**CENTRAL BEDFORDSHIRE COUNCIL COMMENTS ON DEADLINE 5  
SUBMISSIONS**

**LONDON LUTON AIRPORT EXPANSION DEVELOPMENT CONSENT ORDER**

**Version – FINAL**

Figure 3.2: Changes in passenger volumes over the duration of the Proposed Development (mppa)

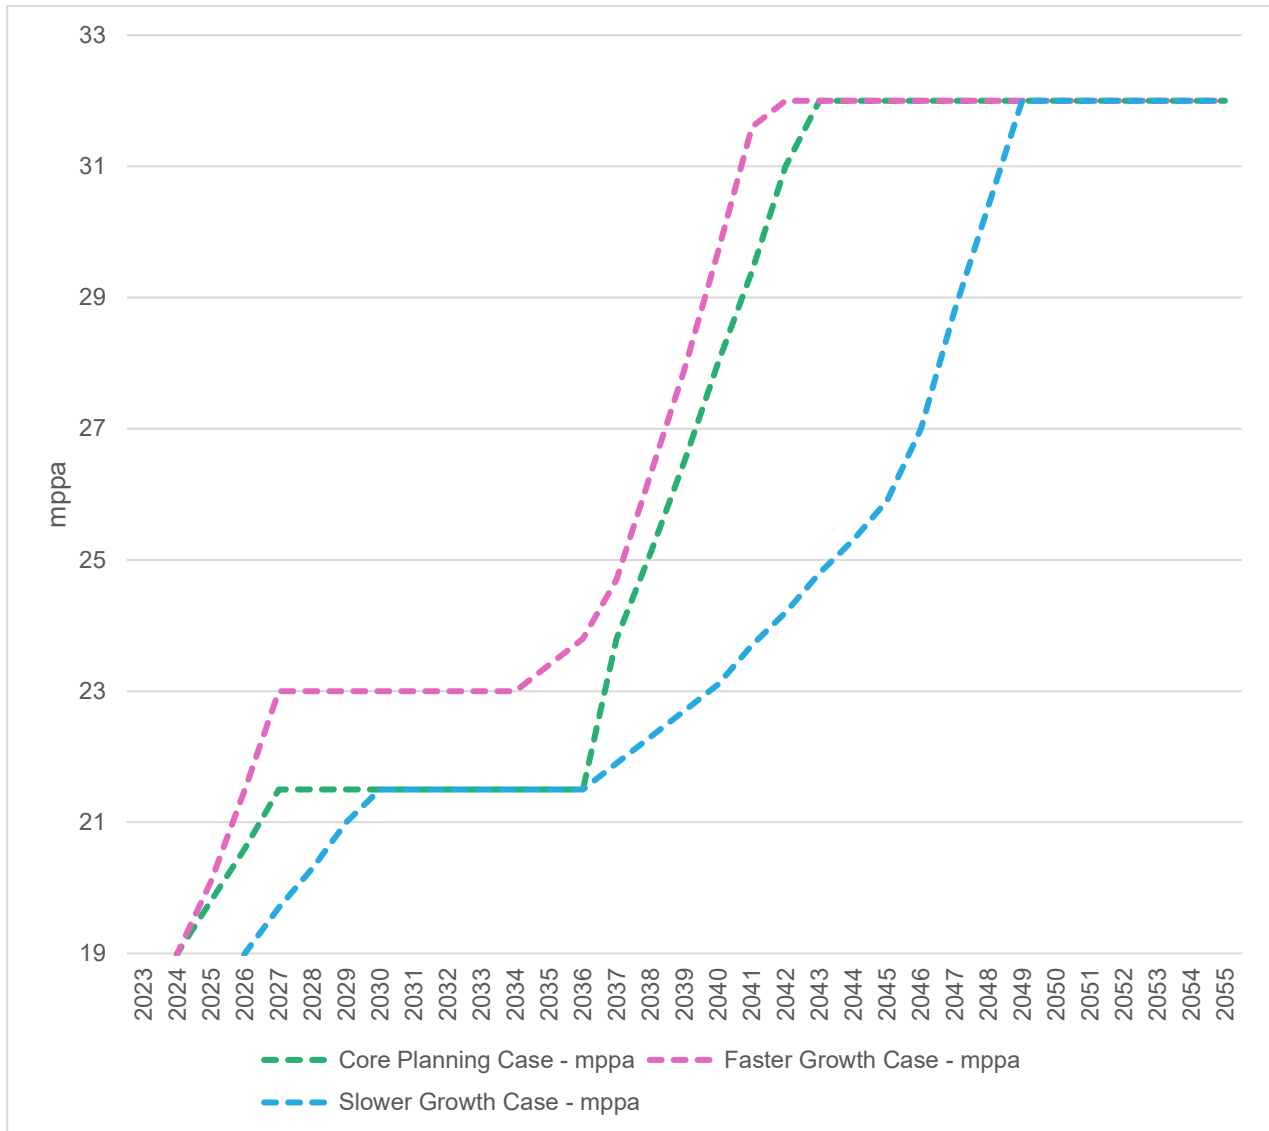
CBC note that the specific concerns raised with regards to the potentially long periods of time when no monitoring would be required under the current proposals within OTRIMMA are supported by the passenger growth projections included in REP5-056 in Figure 3.2, which suggests that, dependent upon the growth assumptions applied, there could be no increase in passenger throughput for the period 2027 to 2036, and therefore no triggering of the need for wider monitoring or assessment under ML1. This was also raised by the joint host authorities in Issue Specific Hearing 7 and within the National Highway submission REP5-091.
